Ref: Planning Application 23/03231/F

On the basis of the information supplied with the application together with responses from relevant agencies, Horley Parish Council **object** to the planning application number 23/03231/F – Hawthorn Hart Land, Wroxton Lane, Horley OX15 6BB.

REVISION - 0 DRAWING NO - MT / 1564 / 1

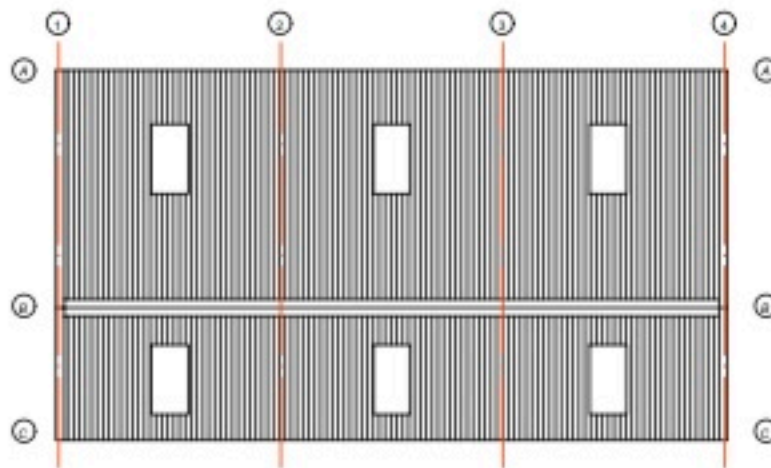
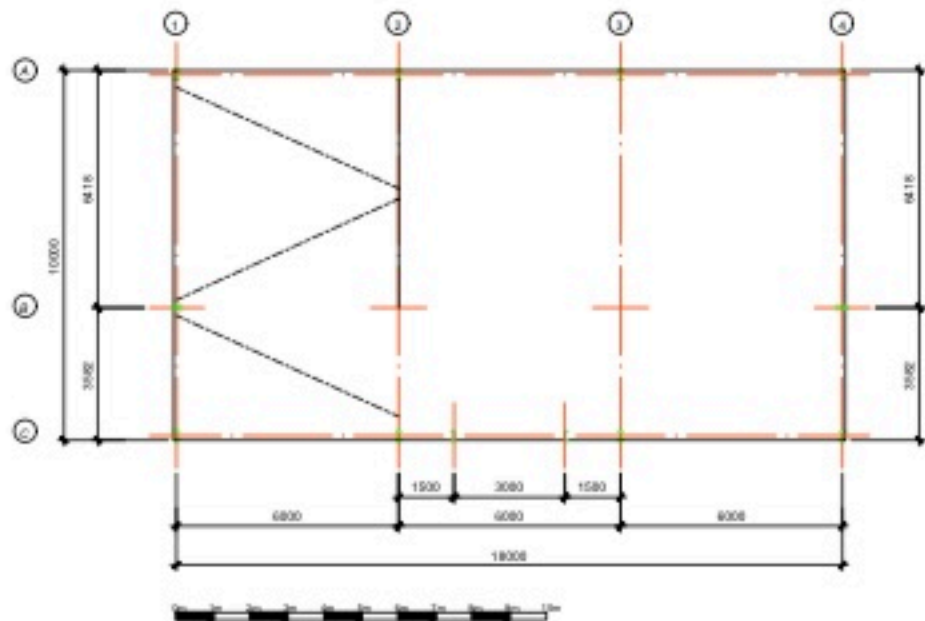
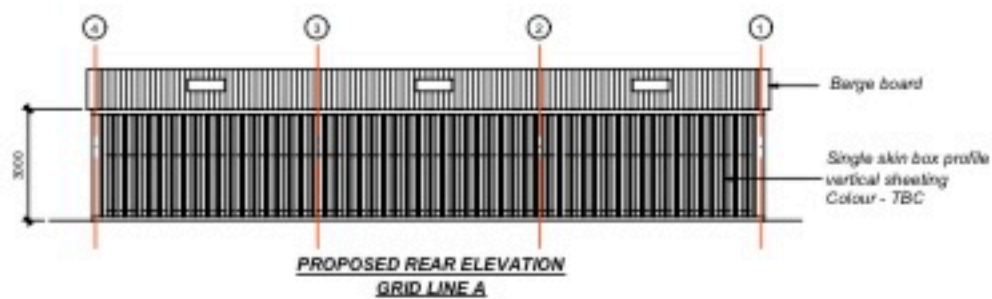
- The proposed barn is of modern construction which is not in keeping with other village structures in the conservation area. It will have to have hard standing which will destroy part of the meadow and given its large footprint will be clearly visible from the road, adjacent houses and nearby footpaths across the land.
